**OXFORDSHIRE COUNTY COUNCIL'S RESPONSE TO CONSULTATION ON THE
FOLLOWING DEVELOPMENT PROPOSAL**

Application no:13/01811/OUT

Proposal: Land And Former Buildings UH11 442 465 466 467 468 470 471 481 492 493 529
593 596 Dow Street Upper Heyford

Location: OUTLINE - Up to 60 dwellings and public open space with associated works

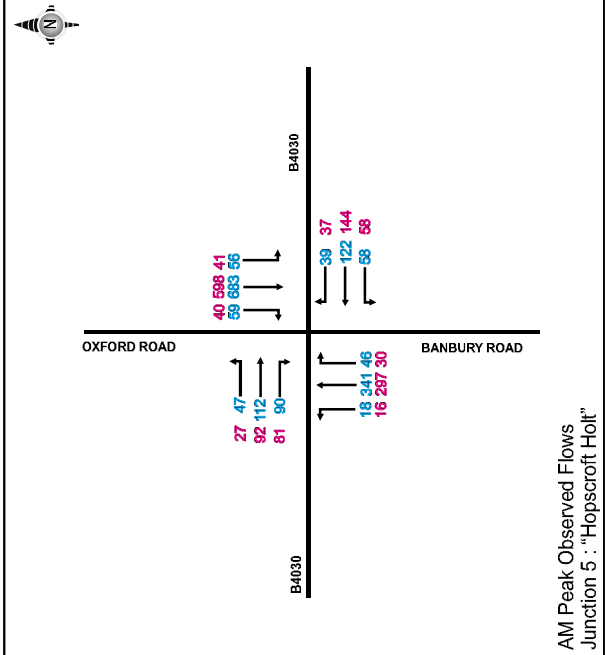
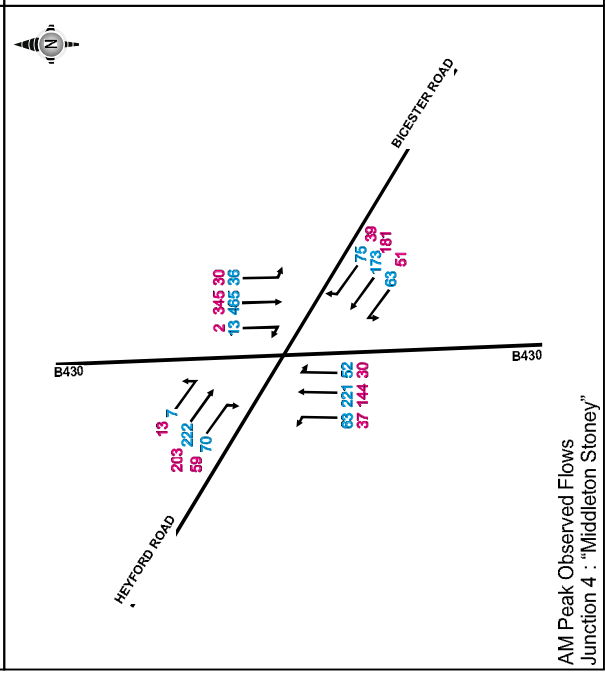
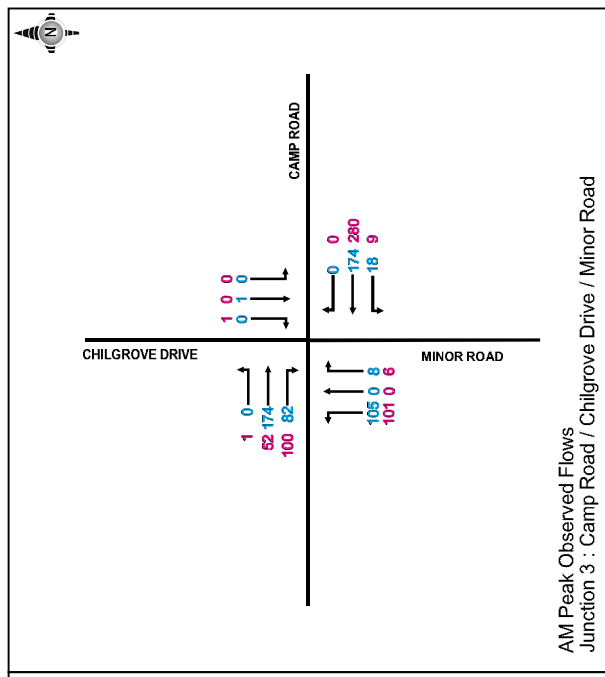
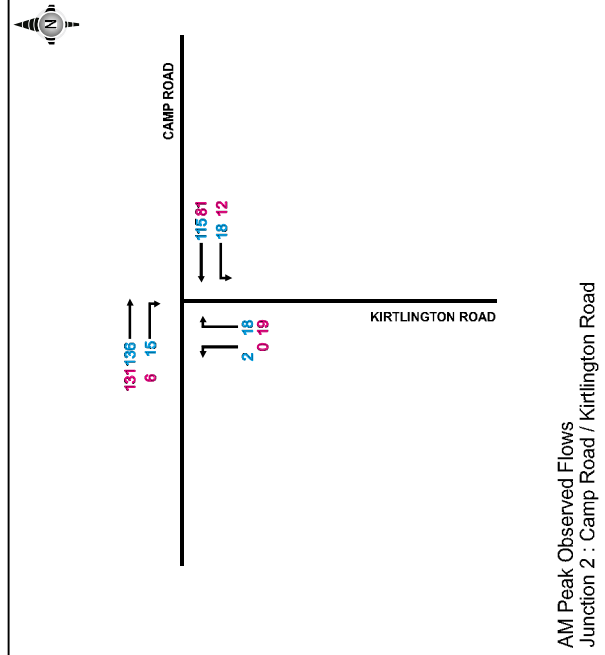
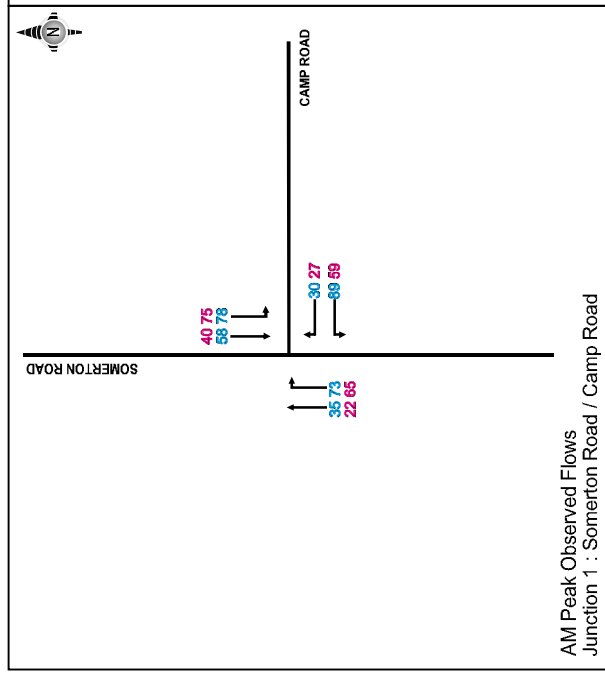
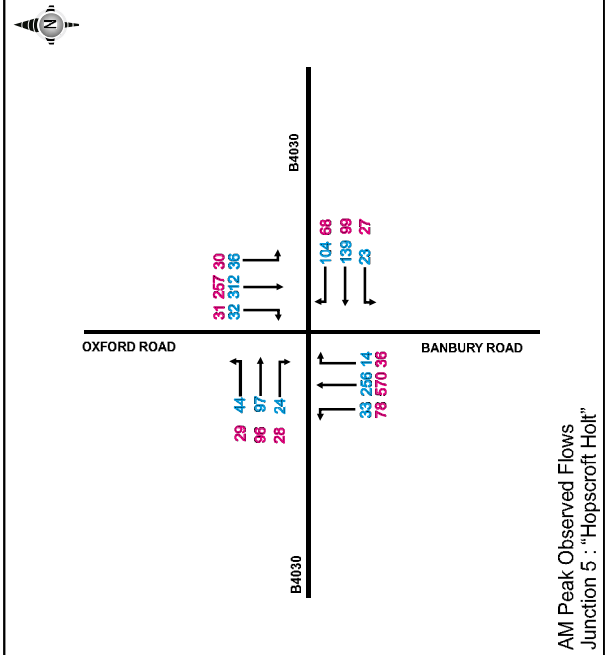
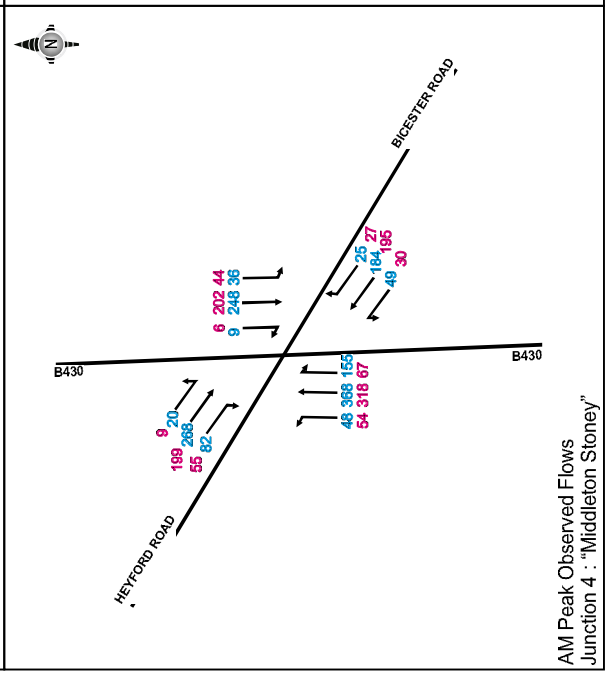
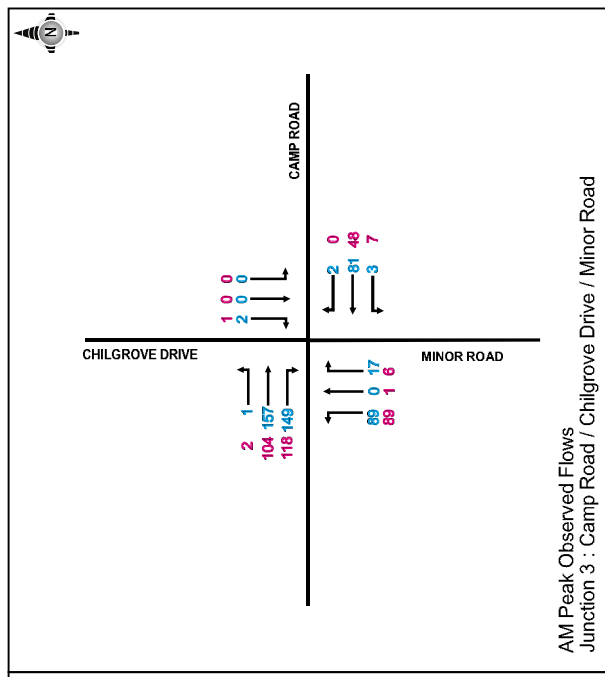
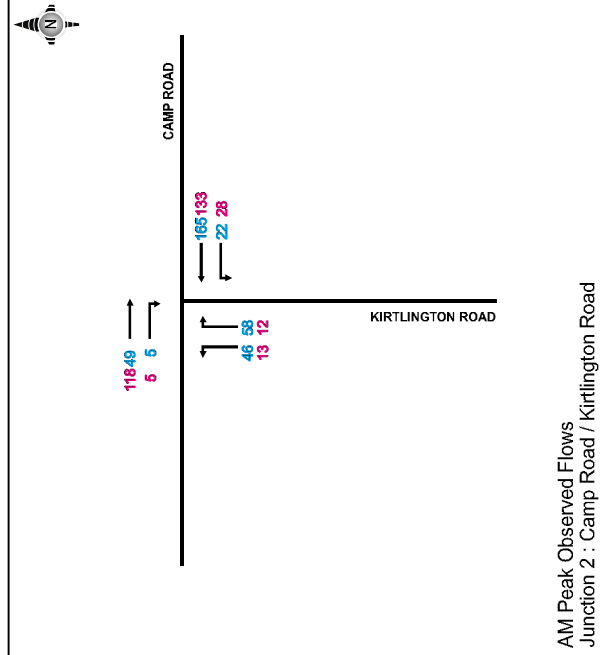
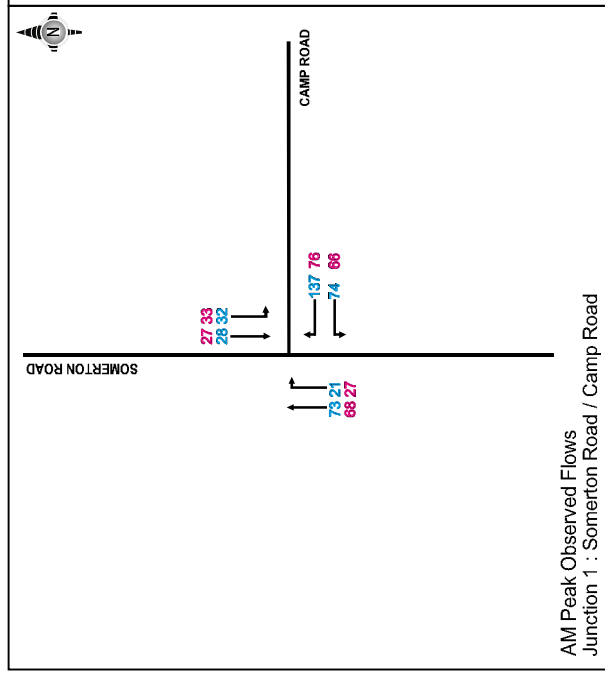
- Figures 4 and 5 in the TS appendix have a number of errors when compared with the manual count data. Also Figure 5 repeatedly refers to AM peak when actually it is looking at the PM peak, which is confusing.
